14 December 2017

File No: R/2017/11/A and R/2017/14/A
Our Ref: 2017/626594

SSD 8517 and SSD 8449 – Australian Technology Park, Locomotive Workshop

4.9.6 Roof Plant Platforms

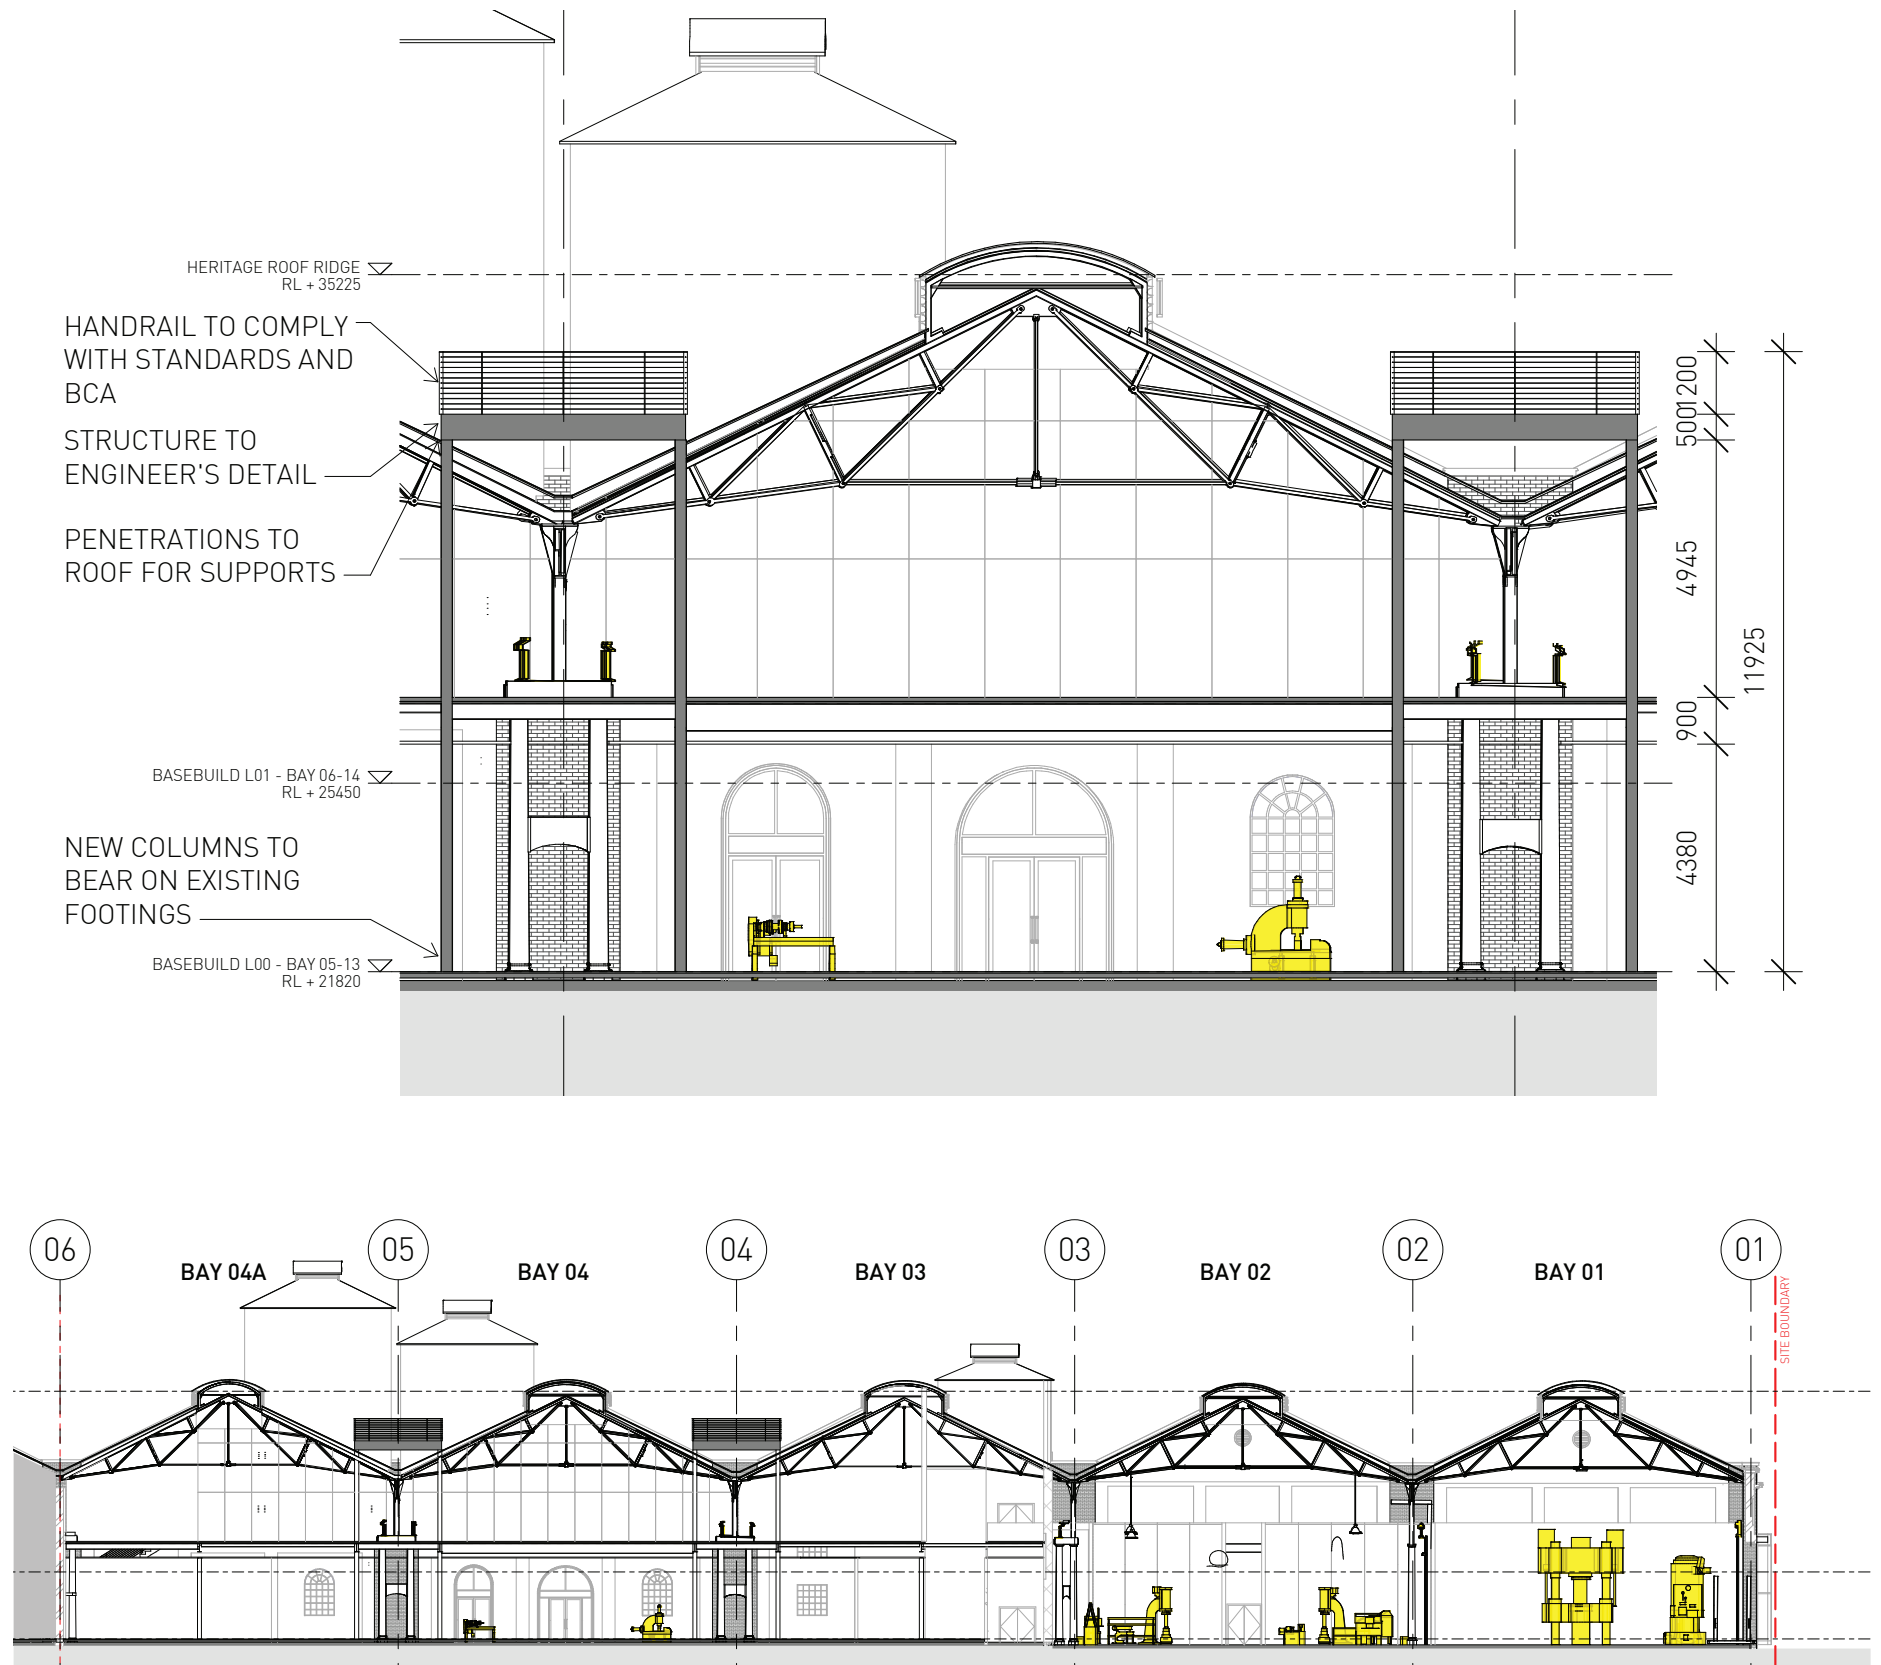
New plant platforms are proposed within the roof valleys between Bays 3/4 and Bays 4/4a to support the proposed supermarket's dedicated plants. These roof plants will require structural supports that will penetrate the existing roofs and will be supported by pairs of new columns. However, design details for these structural supports are lacking in the development application; the information for these structural supports is insufficient to allow thorough assessment of any heritage impact. It is recommended that design details of the roof plants and their structural supports be provided to the City for review and comment prior to the issue of a Construction Certificate.

4.12 Loading Dock

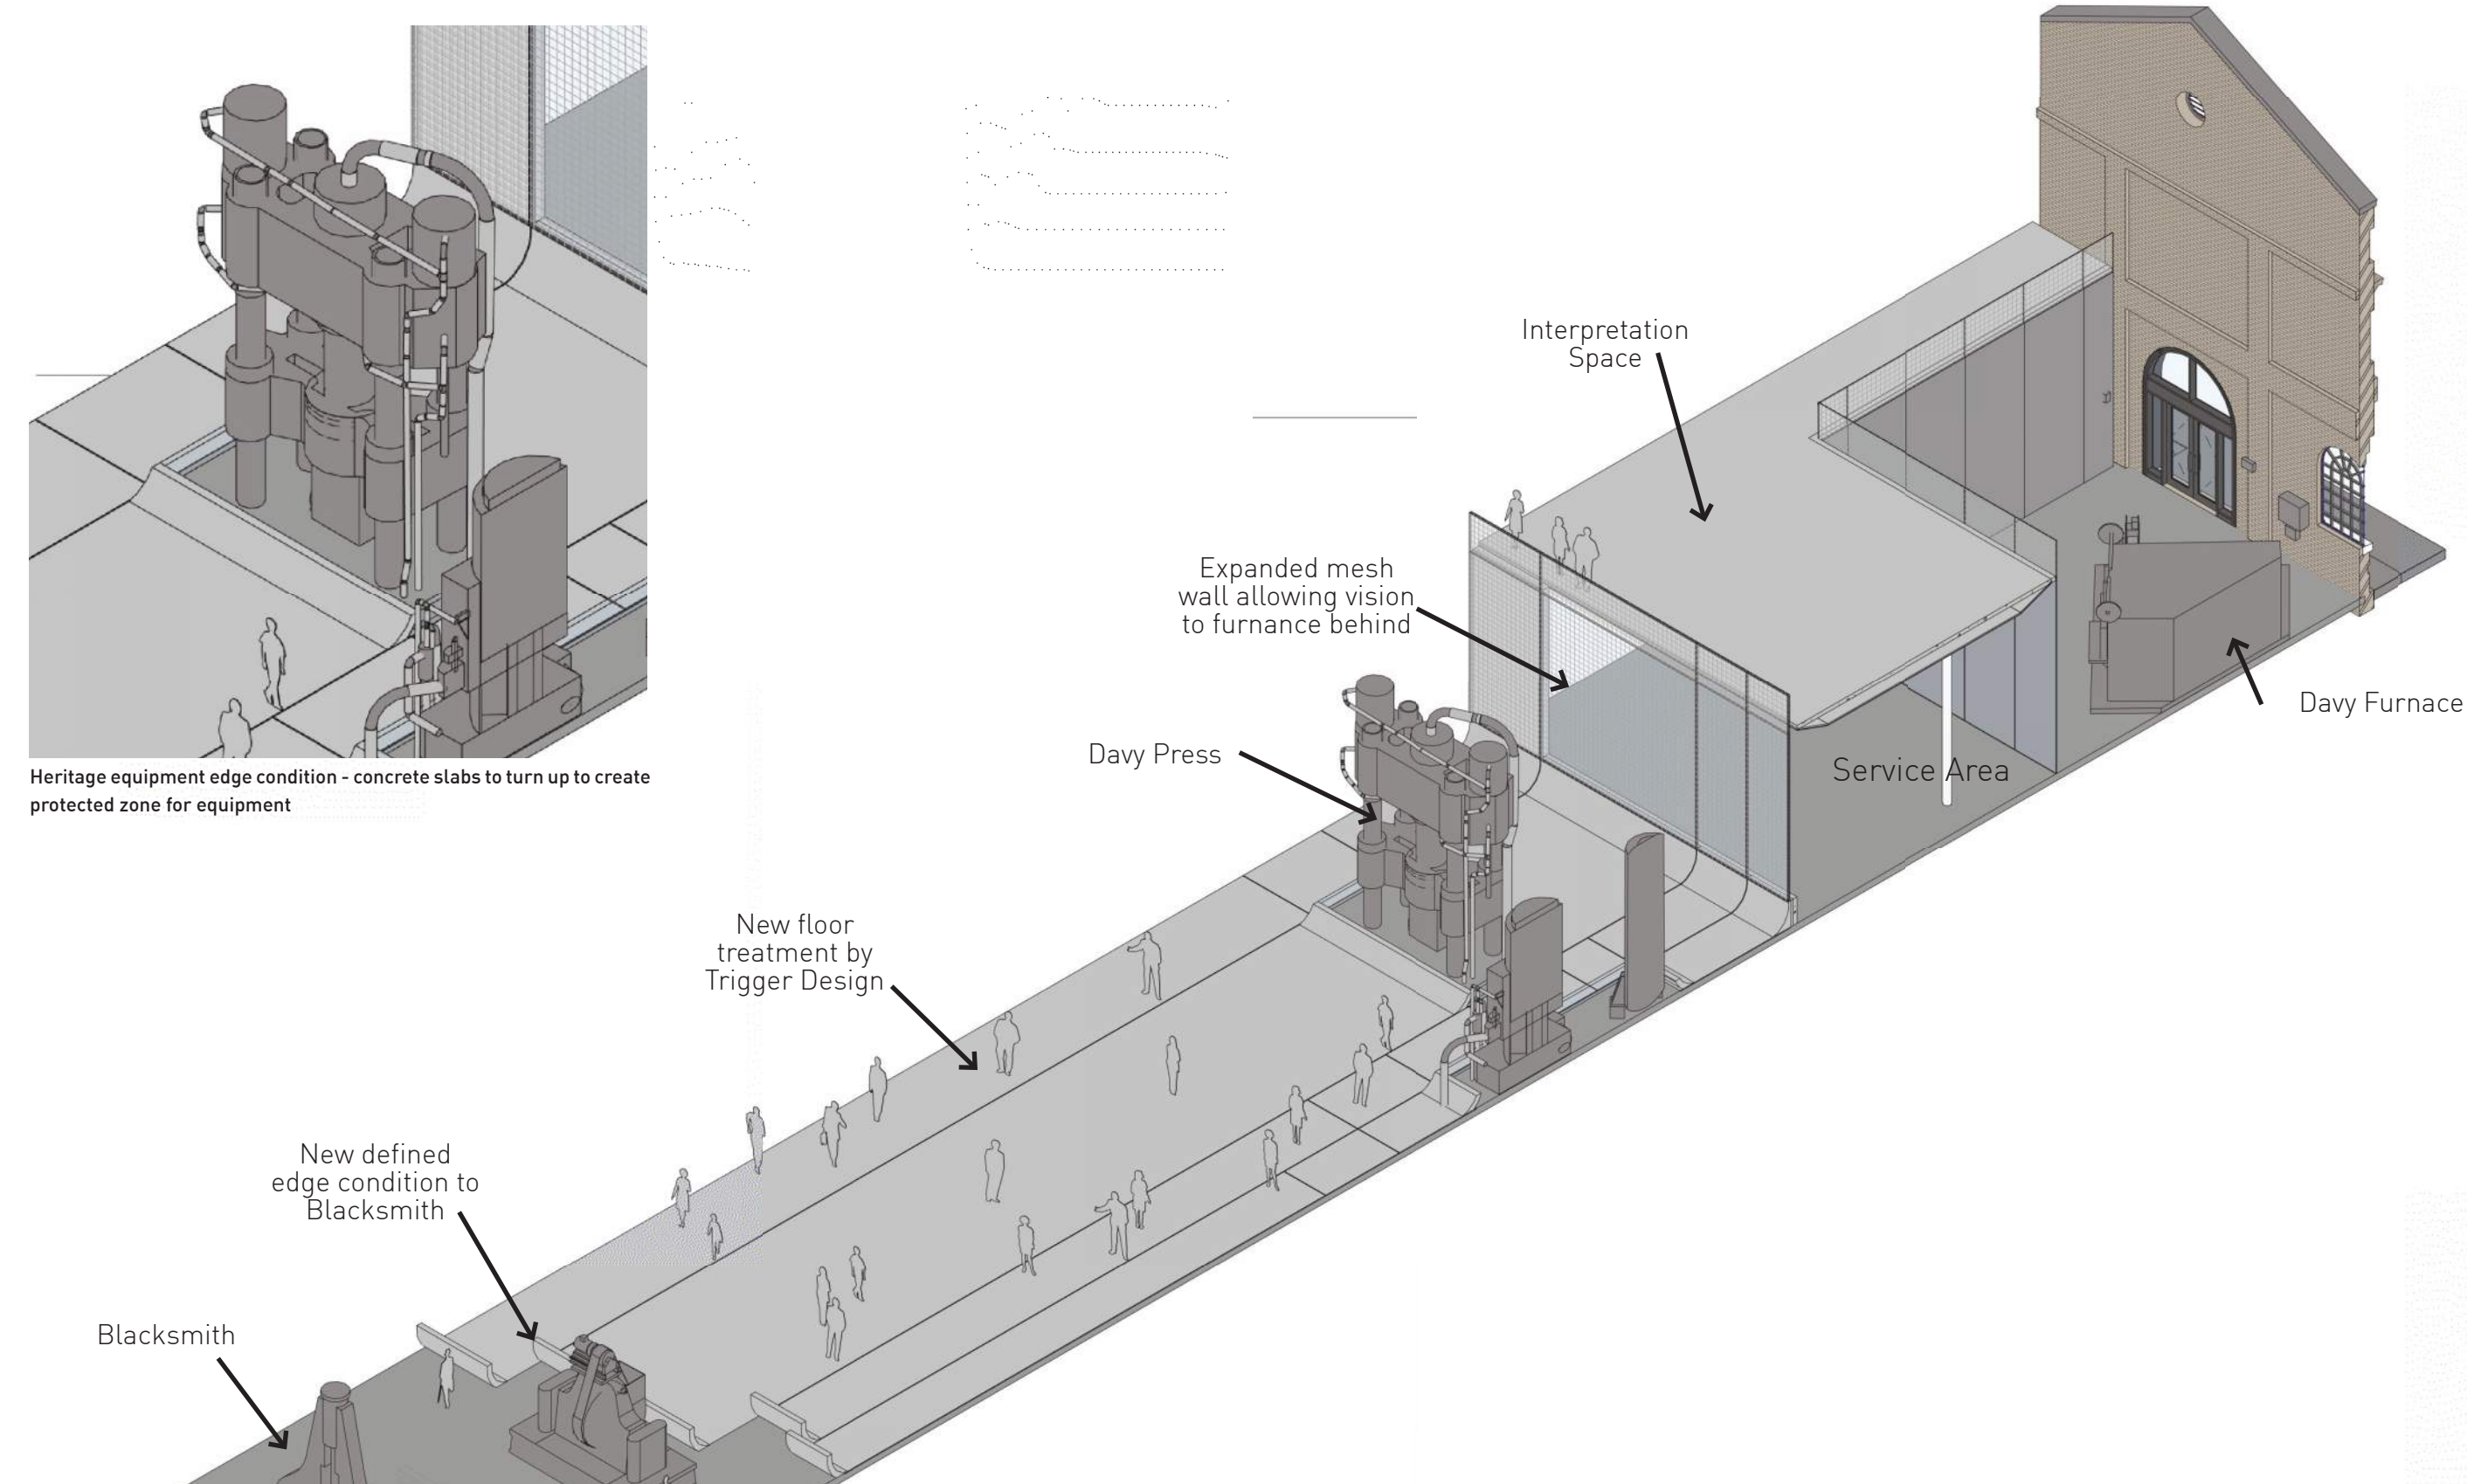
Figure A in the Architectural Design Report shows SRVs (small rigid vehicles) and HRVs (heavy rigid vehicles) encroaching into the enclosure for the Davy Furnace. The western wall is solid while the southern wall is a glazed transparent wall to allow visual permeability and connection to the Davy Furnace from the Bay 1 retail area in the south. Notwithstanding the other comments in this letter regarding the loading dock, the possible or potential conflicts between service vehicle requirements and the Davy Furnace enclosure walls must be resolved in favour of maximum 'breathing space' (buffer zone) around the Davy Furnace. The Department are requested to

require the applicant to consult with the City in the detailed design resolution of the loading dock prior to a Construction Certificate being issued.

Mezzanine plan Bays 1 and 2

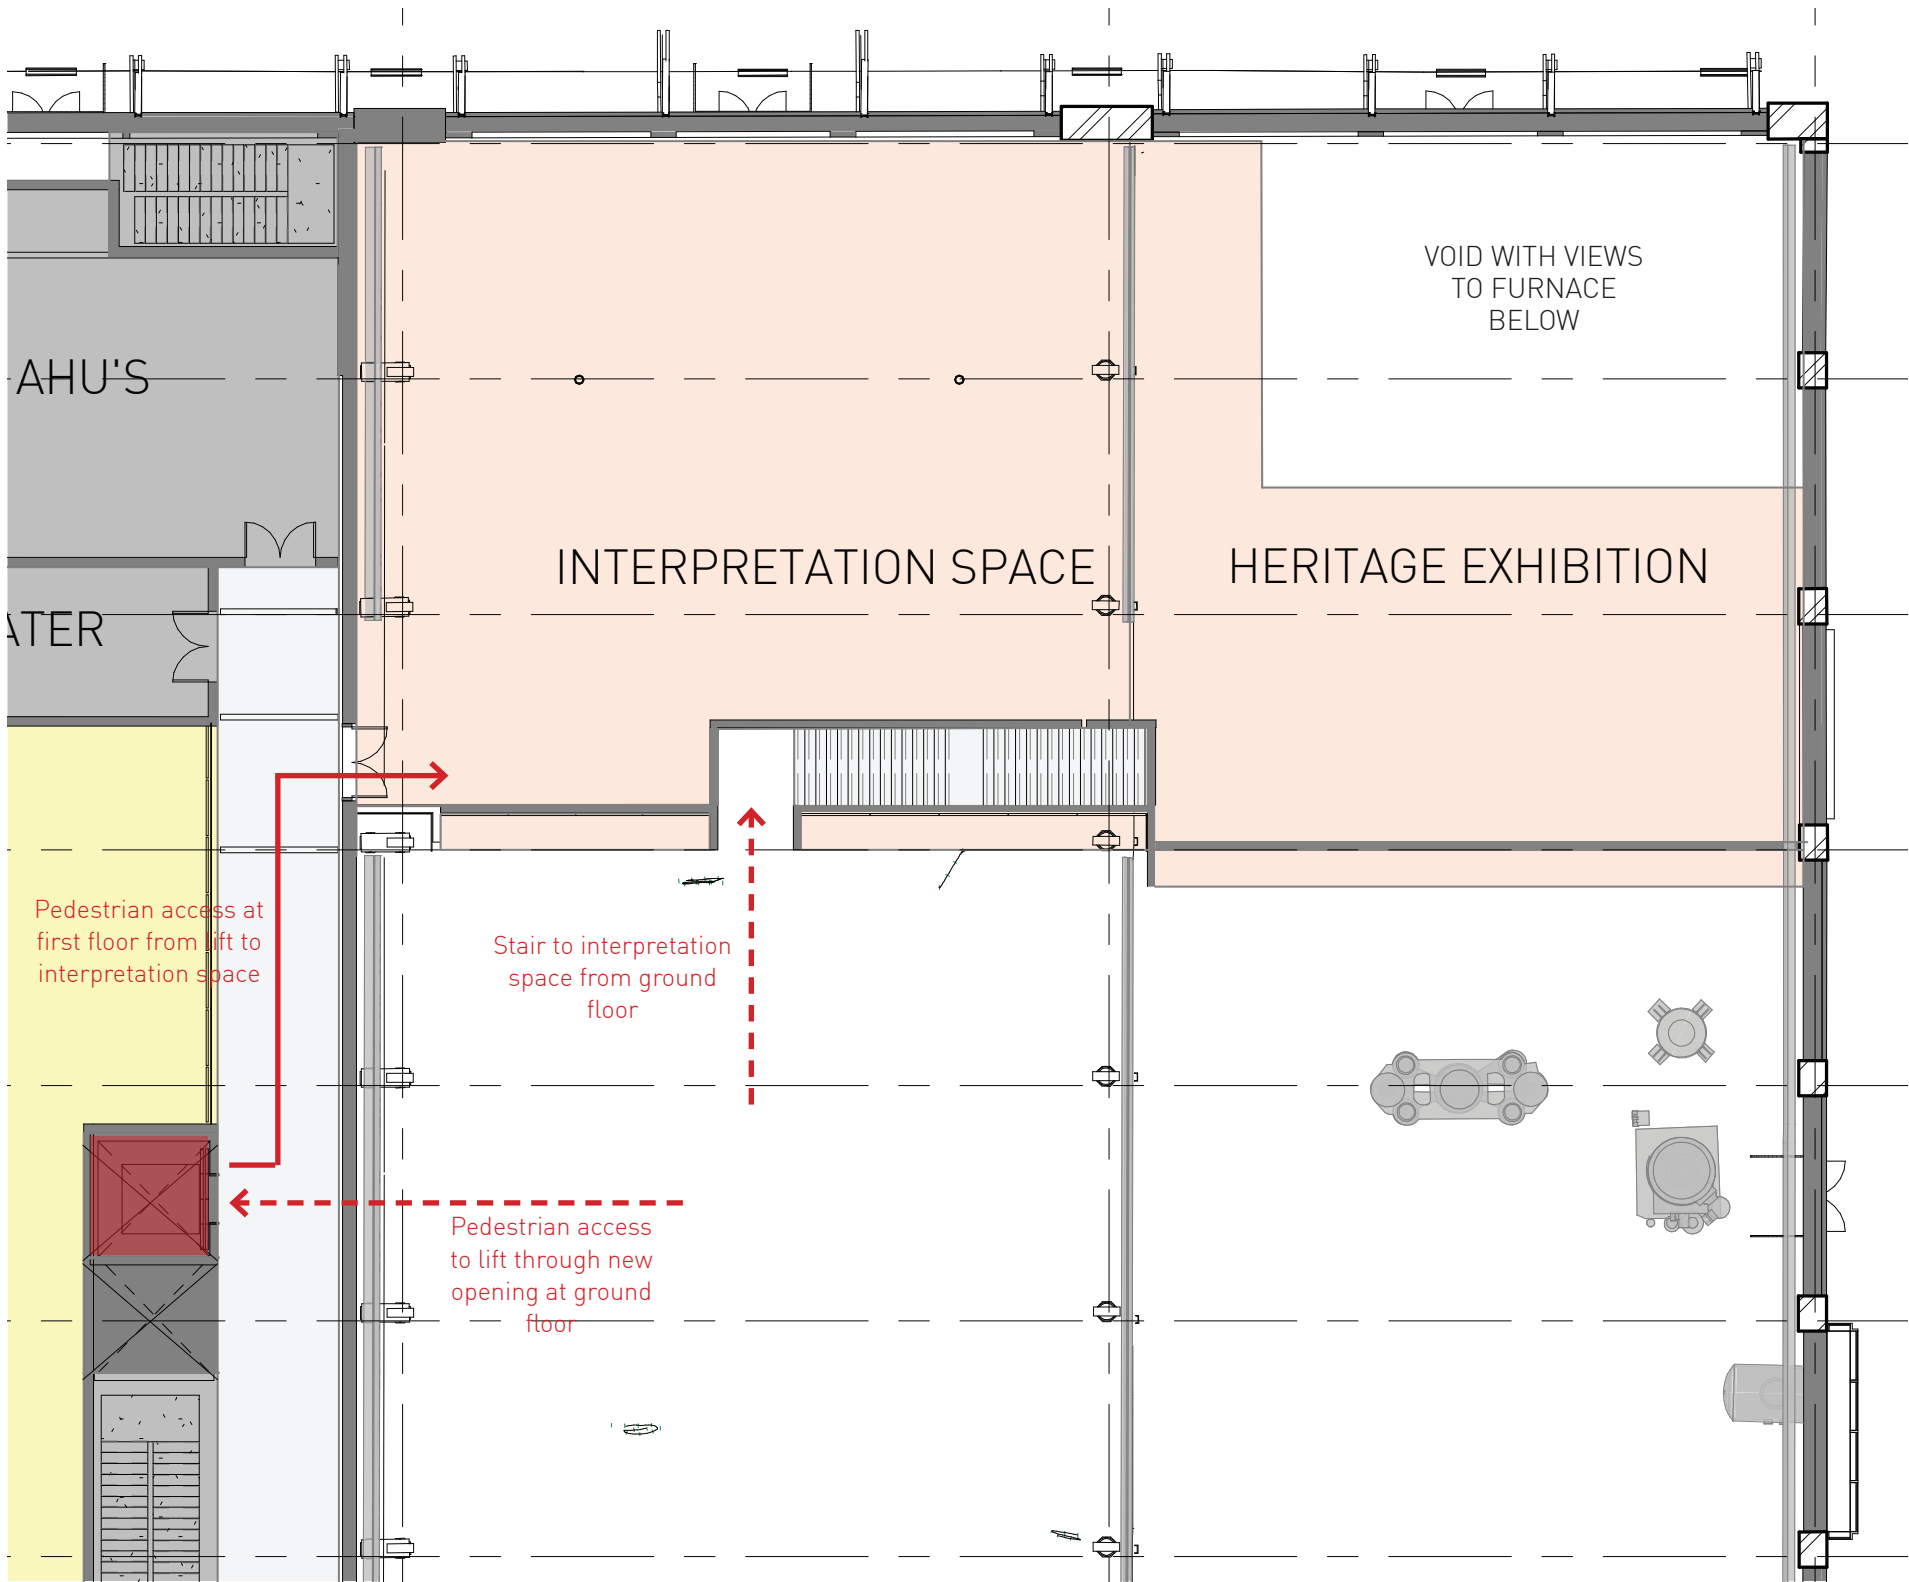
It is understood that a lift from the ground floor to the interpretation space on the first floor is proposed to Bay 3 to minimise material and heritage impact on Bay 2. New insertions, including the lift, are proposed to be reversible without causing material damage upon removal in the future. The lift is disconnected from the stairs with the lift access being from a BOH (back of house) corridor in Bay 3. Different members from the same group (for example, visitors who have children, the infirm and wheelchair users) potentially will head towards the stairs that are proposed in a more public area. However, those wishing to use the lift will have to separate from the group to access and use the lift located at an out-of-sight BOH corridor. It is recommended that the lift and stairs should be co-located adjacent to each other to provide equitable access options from the ground floor to the interpretation space on the first floor. The co-location of access options must avoid or minimise material and heritage impact on the physical fabric and on the quality of significant spaces. Prior to the issue of a Construction Certificate, the City should be further consulted in the detailed design resolution of access options from the ground floor to the interpretation space on the first floor.
